Application No: FG/139/17/PL

Recommendation Report for Planning Permission

LOCATION: Existing Telecommunications Installation
Ferring Water Pumping Station
off Amberley Drive
Ferring

PROPOSAL: Replacement monopole & antennas & 1 No. replacement cabinet.

PROPOSED ELEVATION

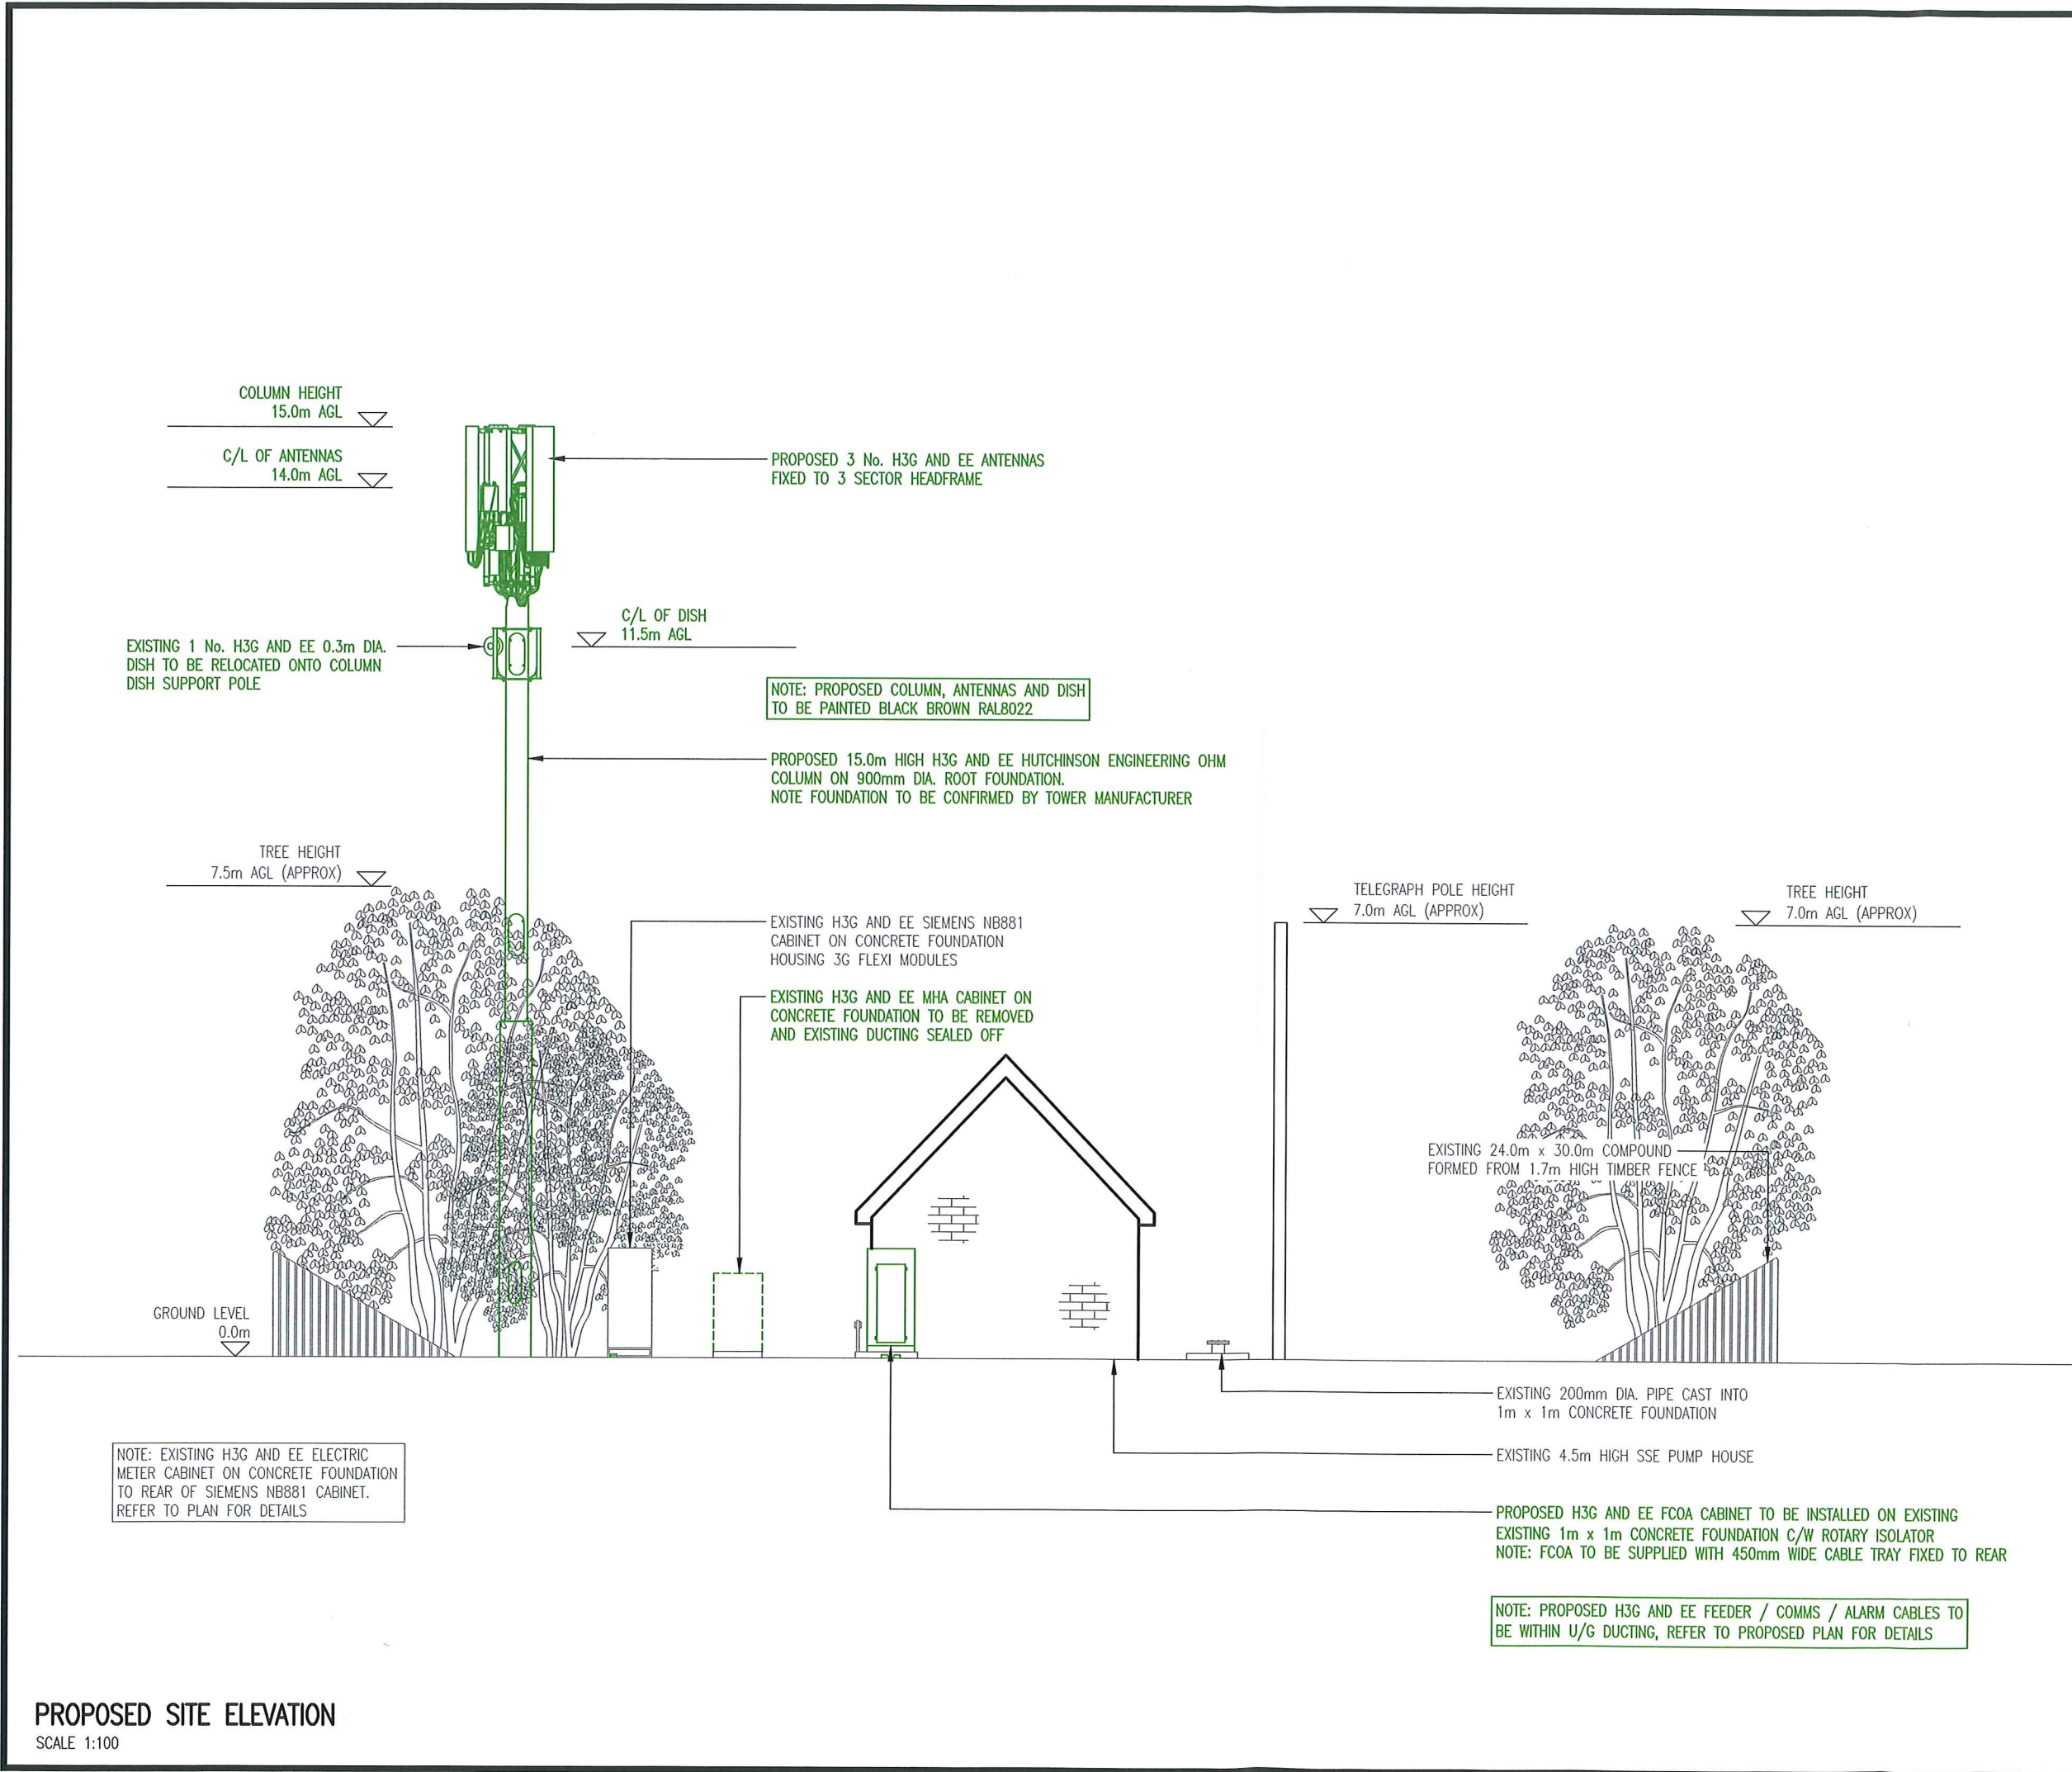
Objection - Concern regarding the height of the proposal to replace existing 12m monopole with a new 15m monopole.

Whilst we appreciate that upgrades may be necessary to meet technological advances, we do not consider that to be 15 metres in the air is necessary when tree management could confine this to the current mast height.

The proposed mast will have a significantly greater visual impact and be very intrusive in a rural area.

The concerns regarding the impact on visual amenity are shared. The prominence of the mast would materially increase. The site lies in an open rural area and the mast would be readily visible from the east, west and south. However, given that this is a site share and it has been satisfactorily demonstrated that there are no suitable alternatives the proposal is considered to accord with policy DEV41 and not be

The site is an established telecommunications installation and the proposal is an upgrade of the existing facilities which represent a site share. It comprises a 3m increase in height of the mast and a 1.2m increase in width to the top of the mast.

The proposal at this increased height would be readily noticeable from all views along the seafront particularly the south and east. The increased bulk would be prominent and project above the horizon and intrude upon the generally uninterrupted views towards the sea from the west and towards the woodland known as Ilex Way to the north. However it would not appear as a new and alien element given the presence of the existing mast. The building and trees at the existing compound would visually screen the lower portion of the mast and cabinets and the existing telegraph poles assist in assimilating the existing pole against the sky line. It is accepted that the new structure increases the height and is bulkier than the existing installation. Whilst the area is largely open the sea vista and skyline are already interrupted by the 7m high trees on the site and the 5m high building within the existing compound.

The development is located in a visually prominent site but it is a site share and it has been demonstrated that there are no suitable alternative locations. It is not considered that the 3m increase in height of the existing mast and the increased head frame width of 1.2m are sufficient to warrant refusal of the application in terms of the resultant harm to visual amenity. The proposal therefore accords with policies DEV41 and GEN7 of Arun District Local Plan.
